**Consultation Response from KC, Conservation & Design****2023/93584 and 2023/93585 - 145, Trinity Street, Huddersfield, HD1 4DZ****Erection of extensions and alterations to form 4 flats (Listed Building within a Conservation Area)****Listed Building Consent for erection of extensions and alterations to form 4 flats (within a Conservation Area)****Date Responded: 16.02.2024****Responding Officer: S Pickles****Responding Ref:**

drawing title
EXISTING PLANS AND ELEVATIONS

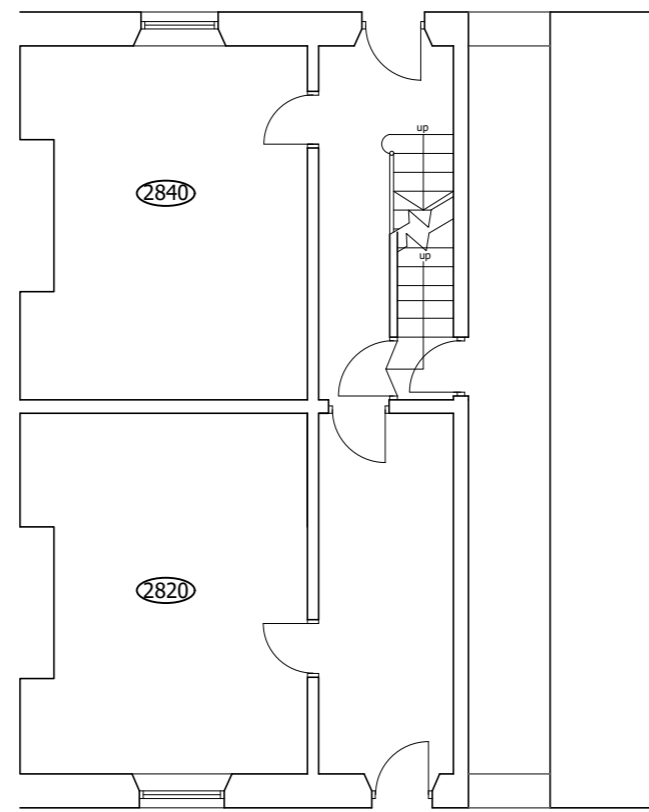
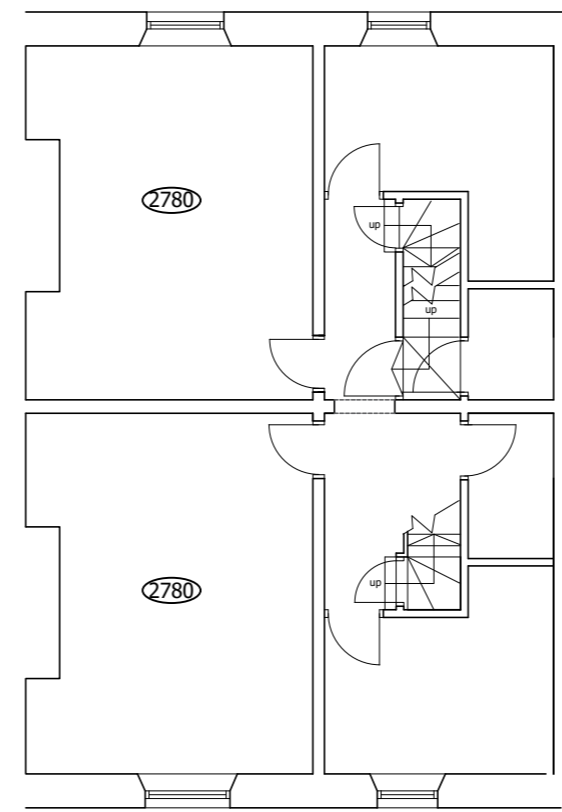
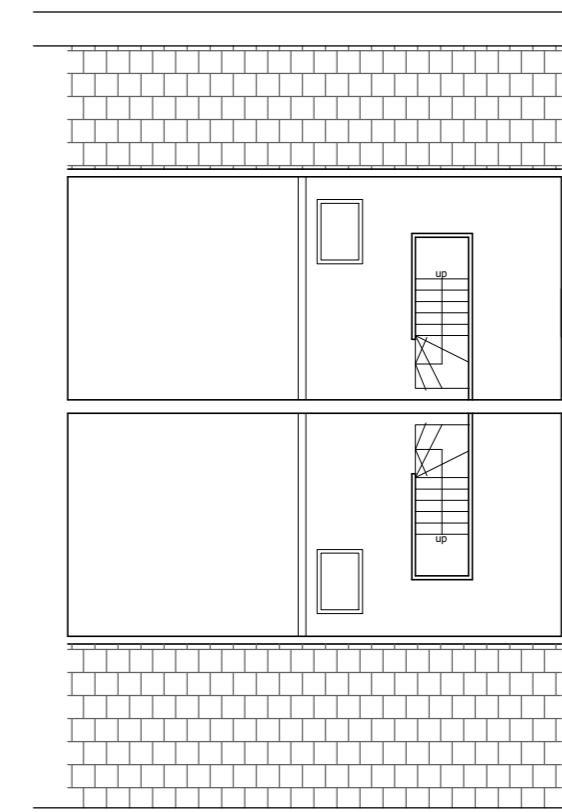
Concerning the internal works, within the basement it is proposed to demolish/ remove the extant historic stone stairs. We object to this element of the proposal. The extant stone stairs form a part of the character of the building, which contributes to its significance. The demolition would cause harm to the building, of which there is no justification. We would therefore advise that the stairs be retained and incorporated into any proposed scheme. We would however not support their loss.

It is also proposed to incorporate a bathroom/WC into the basement area. It appears that there are extant stone flags within the basement and there do not appear to be any details as to how the fit-out would impact upon the historic stone flags. Equally, there is no detail regarding the finish to the walls.

We are concerned as there is no indication of how these elements will be treated and this detail is required. To the second floor (attic space) it is proposed to convert it into a bedrooms. We have no issues with the principle however, it is proposed to add 2 additional roof lights, 1 to the front and 1 to the rear.

We could support the additional roof light to the rear however, we would object to the additional roof light to the front. While there is an existing roof light to the front roof plane it is visible, and an additional roof light would cause further visual impact. In addition, it is not clear that the existing roof light and roof works ever gained consent.

We also note from the submitted application form and plans that it is proposed to replace existing timber windows with uPVC. We would object to the use of uPVC and any replacement windows would be required to be constructed in timber. This would be subject to joinery details being submitted for assessment. This would equally apply to any proposed doors for the property.

We have also noted that rainwater goods which as existing do appear to be cast metal, are to be replaced with uPVC. We would again object to the use of uPVC. Any historic cast metal rainwater goods should be retained and repairs, if possible or replacements should be in matching detail in cast metal.
